**KIRKLEES METROPOLITAN COUNCIL
INVESTMENT & REGENERATION SERVICE**

Reference No: 2020/62/90224/E

Site Address: 125, Oxford Road, Dewsbury, WF13 4EH

Description: Erection of detached dwelling and first floor extension to existing dwelling (modified proposal)

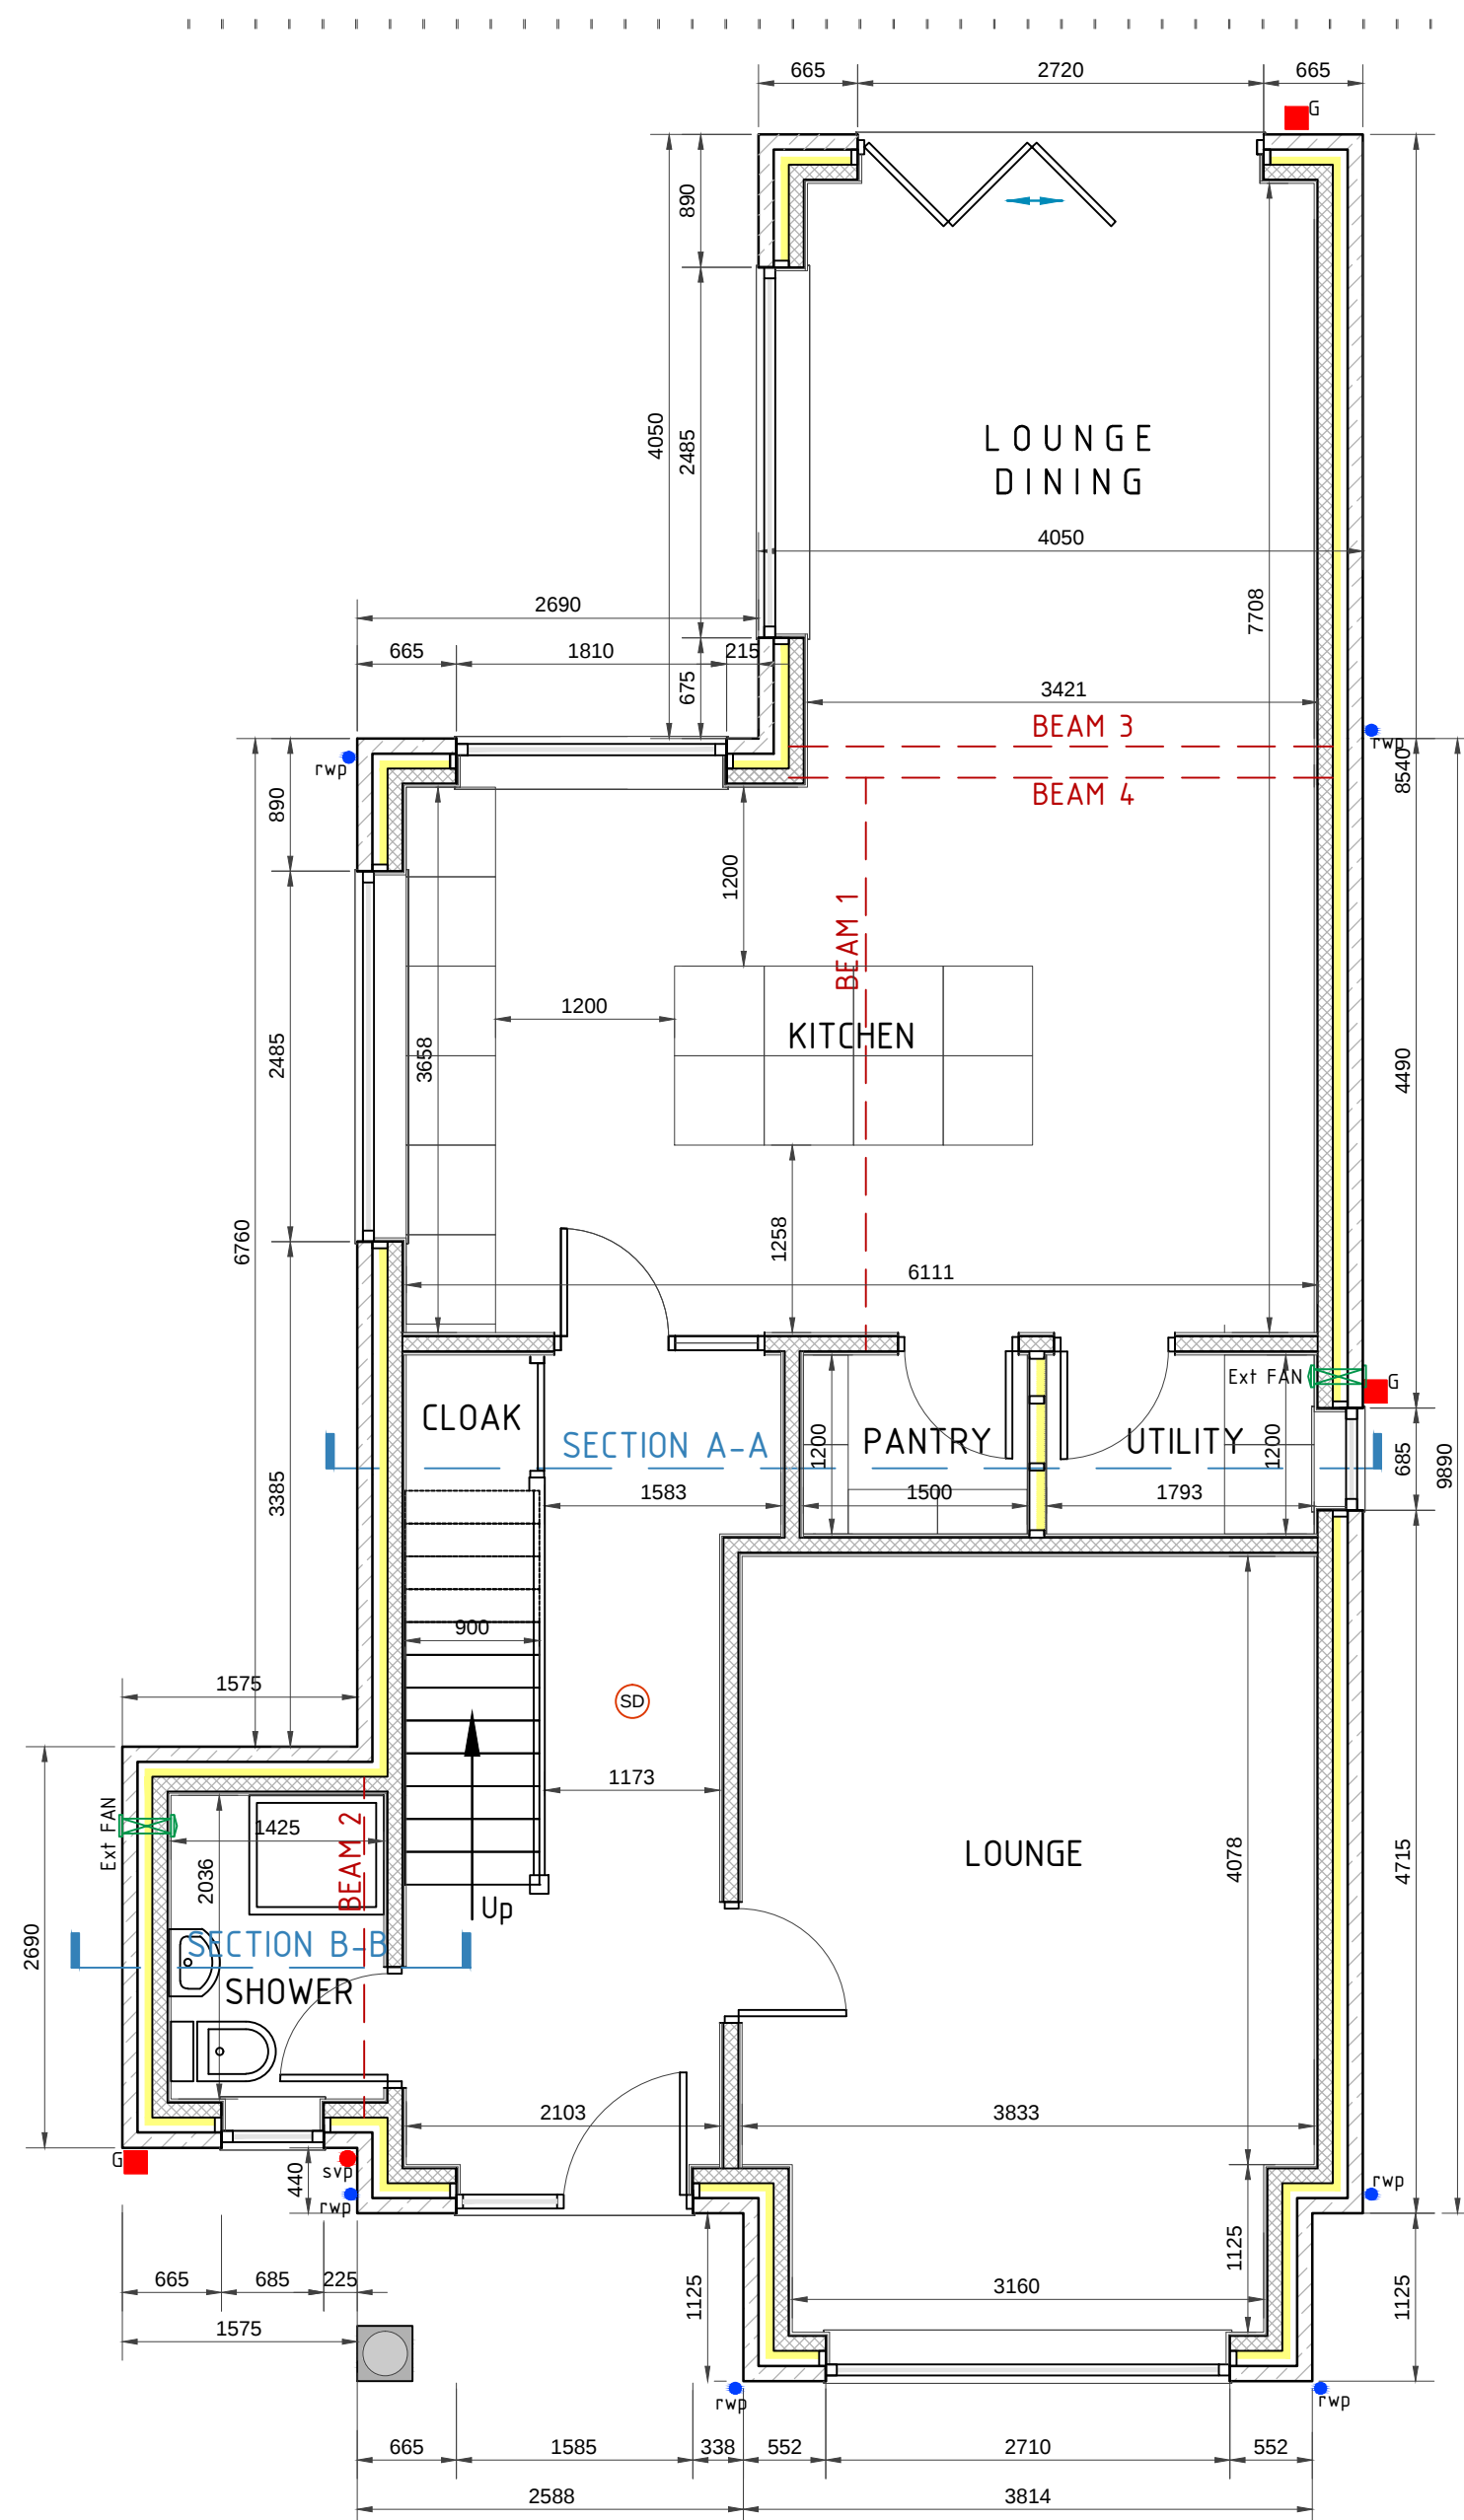
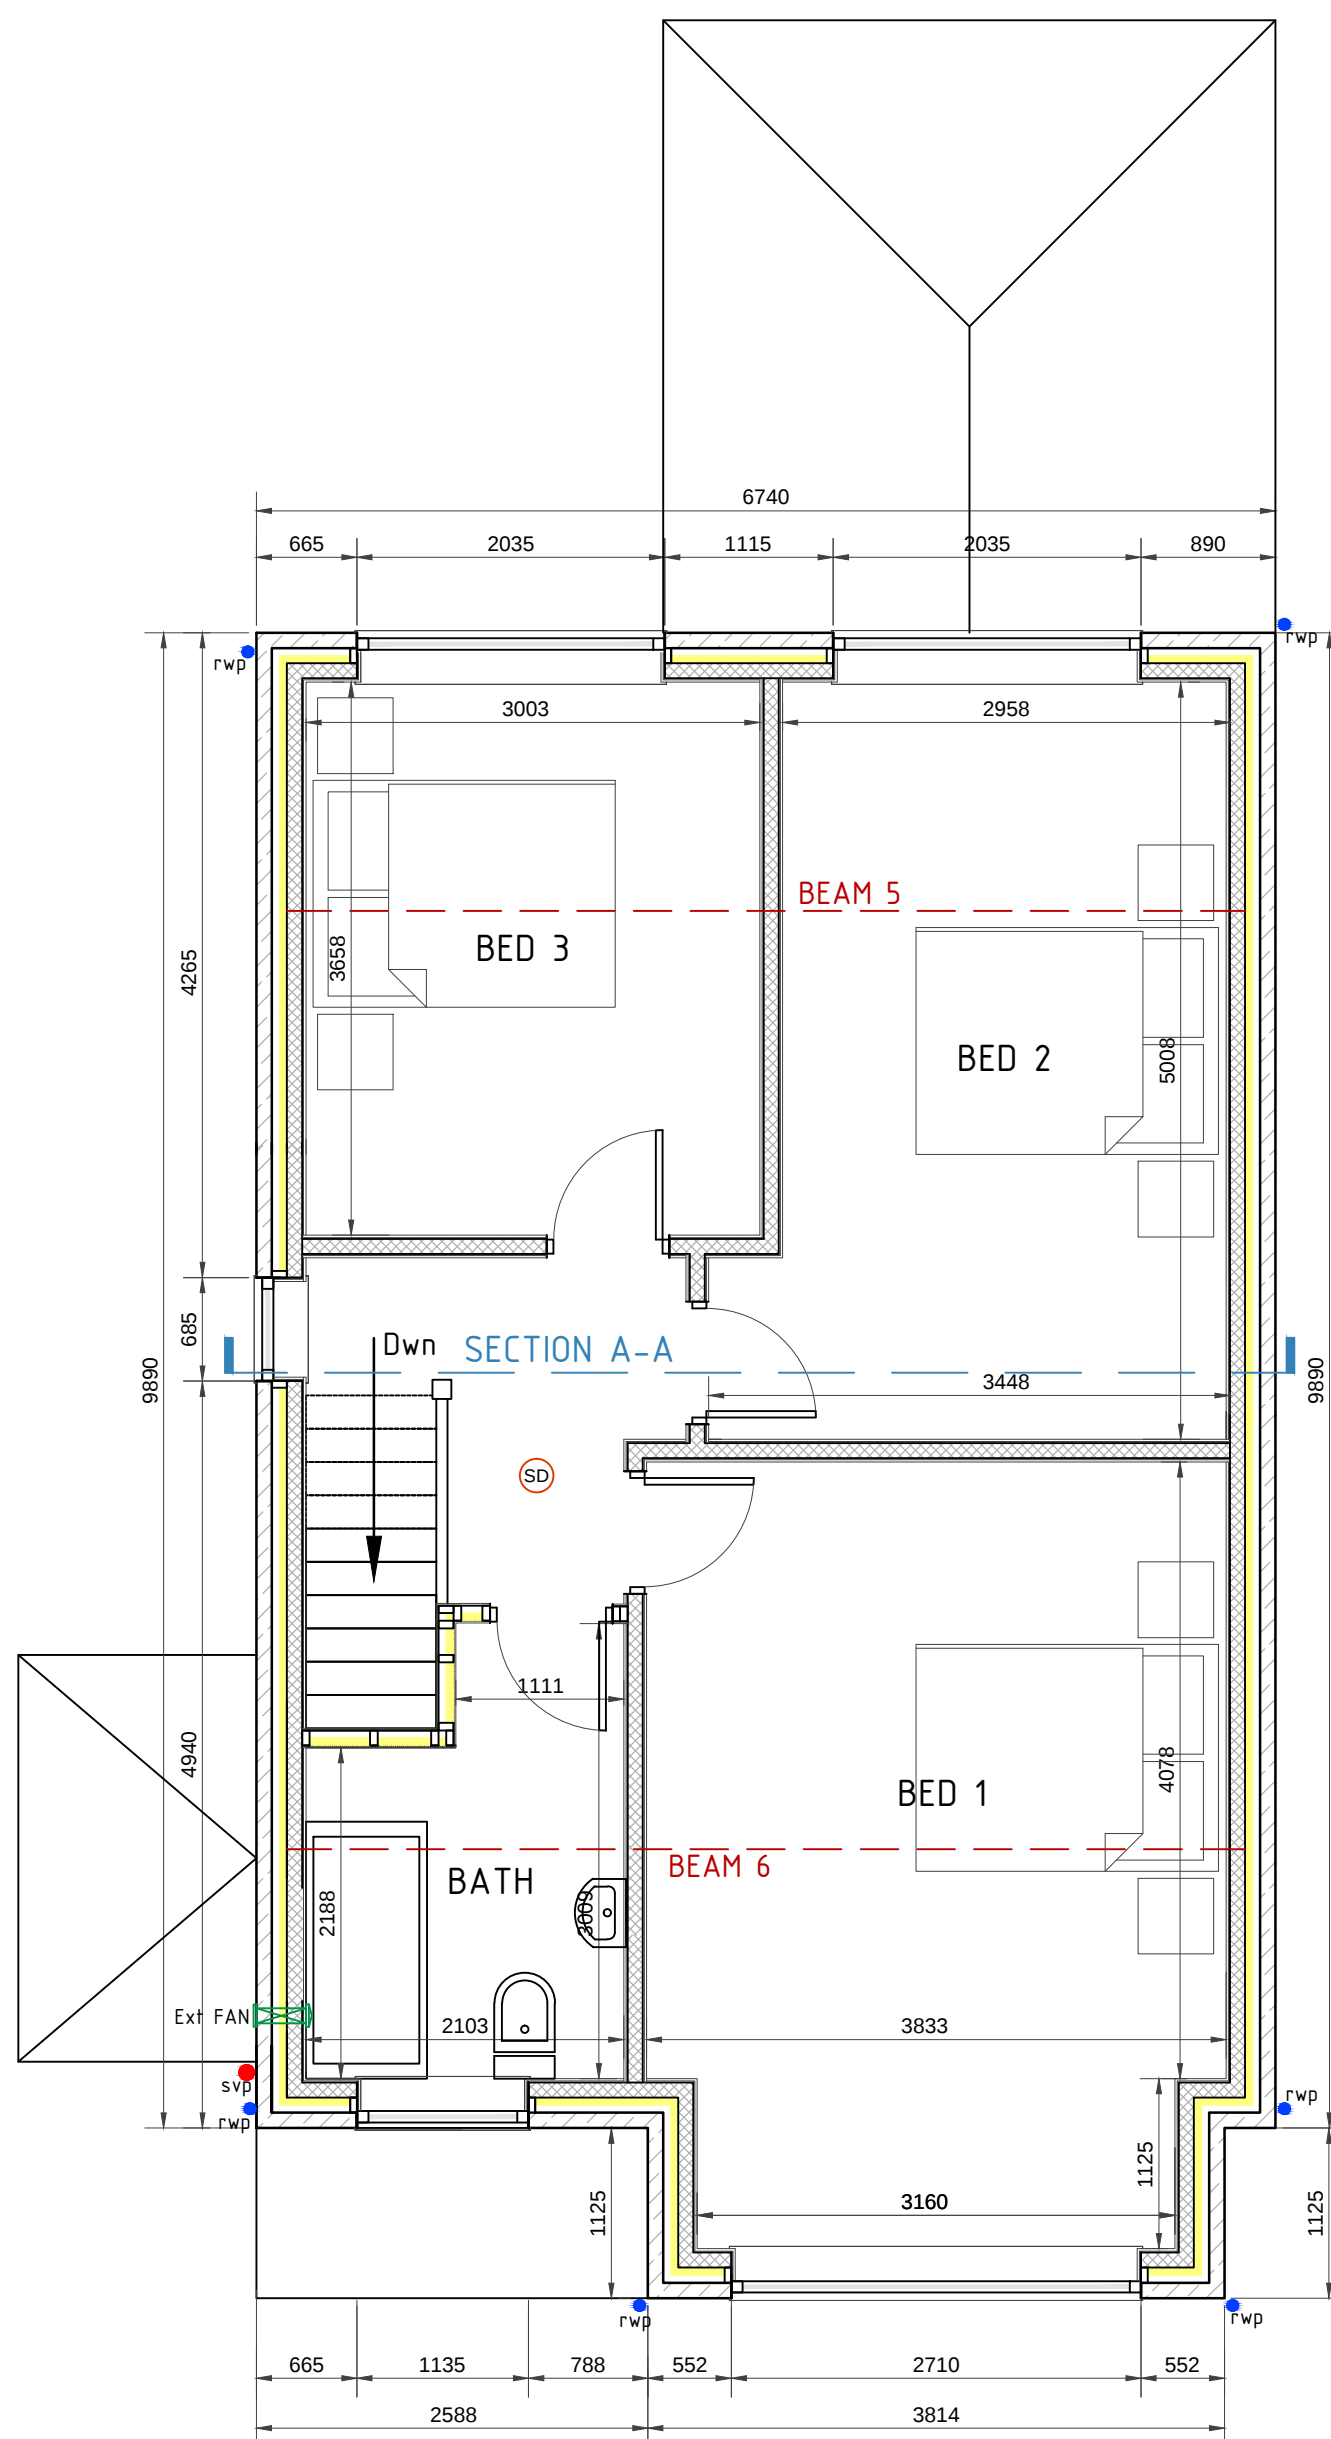
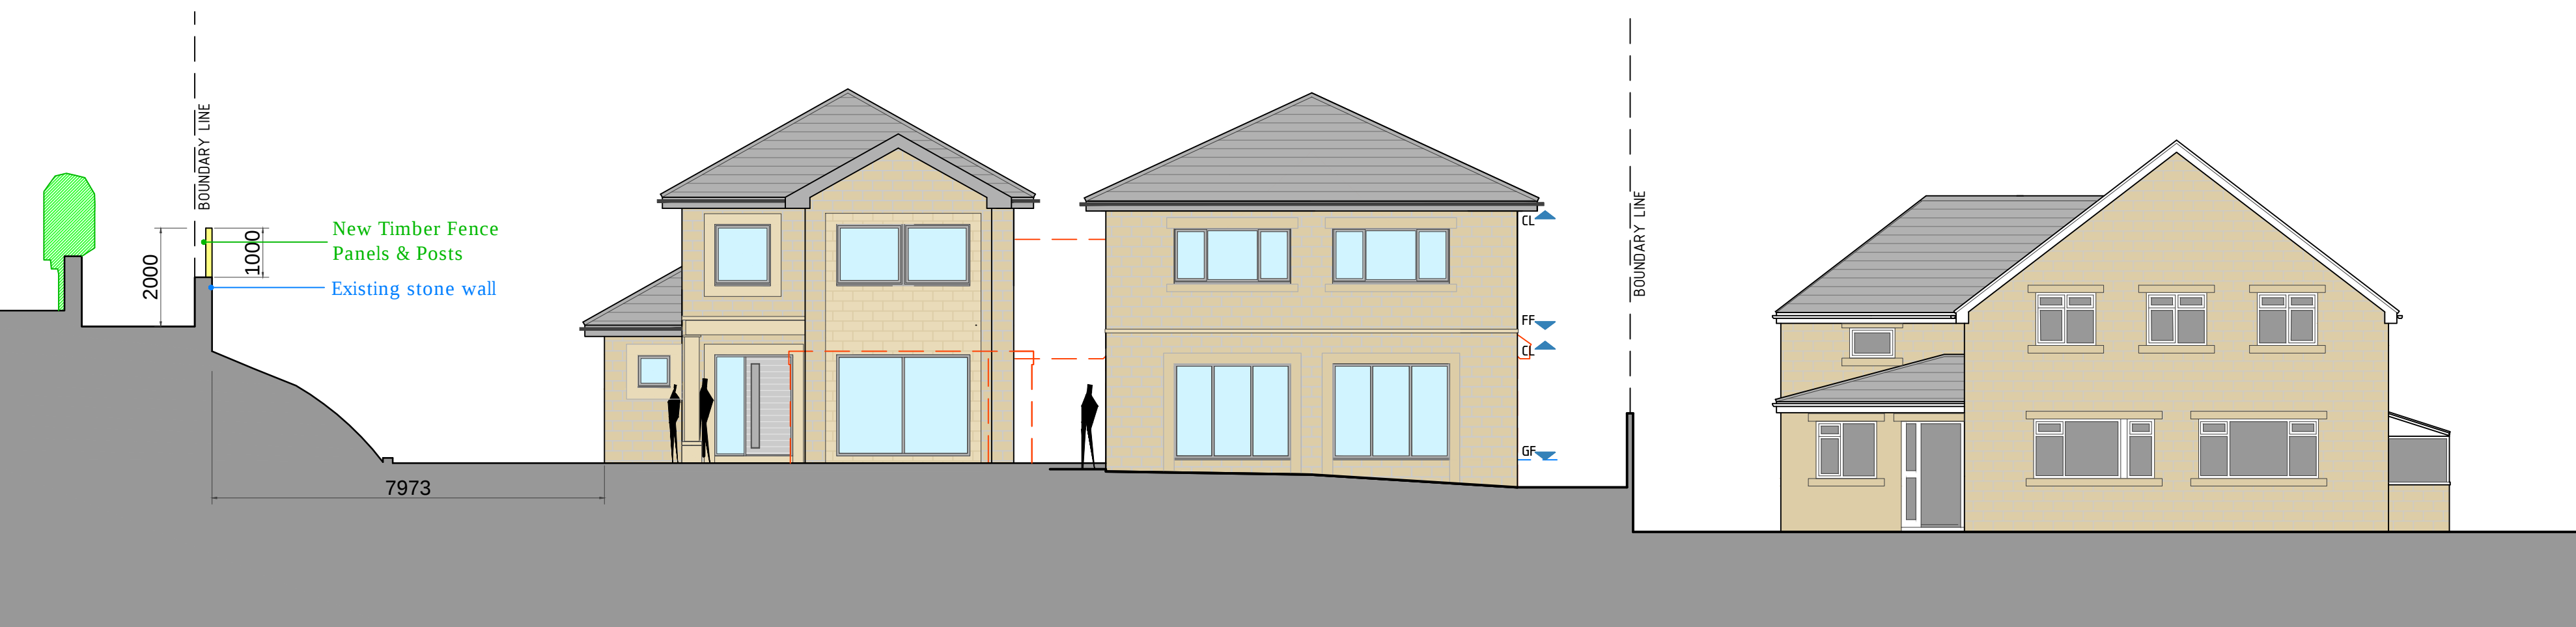
The proposed new dwelling as approved, is a detached three bedroom, two storey property with a hipped roof. The proposed revision to the approved scheme is for the erection of an additional room at the rear of the property which would project a further 4.05 metres from the approved rear elevation. Alterations are also proposed to the fenestration detailing and the use of Ashlar stone blocks to the front elevation is no longer proposed.

It is considered the proposed addition to the approved footprint of the new dwelling would result in a cramped form of development, taking into account the site constraints with the plot tapering significantly to the rear adjacent to the public footpath. The additional footprint of the dwelling would occupy a significant amount of the private amenity space available to serve the dwelling and it is not considered the plot due to its size constraints is sufficient to accommodate the footprint now proposed, even taking into account that the proposed addition would be single storey. Indeed, extensive negotiations took

1. The proposed addition to the approved footprint of the new dwelling would result in a cramped form of development, taking into account the site constraints with the plot tapering significantly to the rear adjacent to the public footpath. The additional footprint of the dwelling would occupy a significant amount of the private amenity space available to serve the dwelling and it is not considered that the plot, due to its size constraints, is sufficient to accommodate the footprint now proposed, even taking into account that the proposed addition would be single storey. The proposal would therefore be contrary to Policy LP24 of the Kirklees Local Plan, and guidance contained within Chapter 12 of the National Planning Policy Framework.
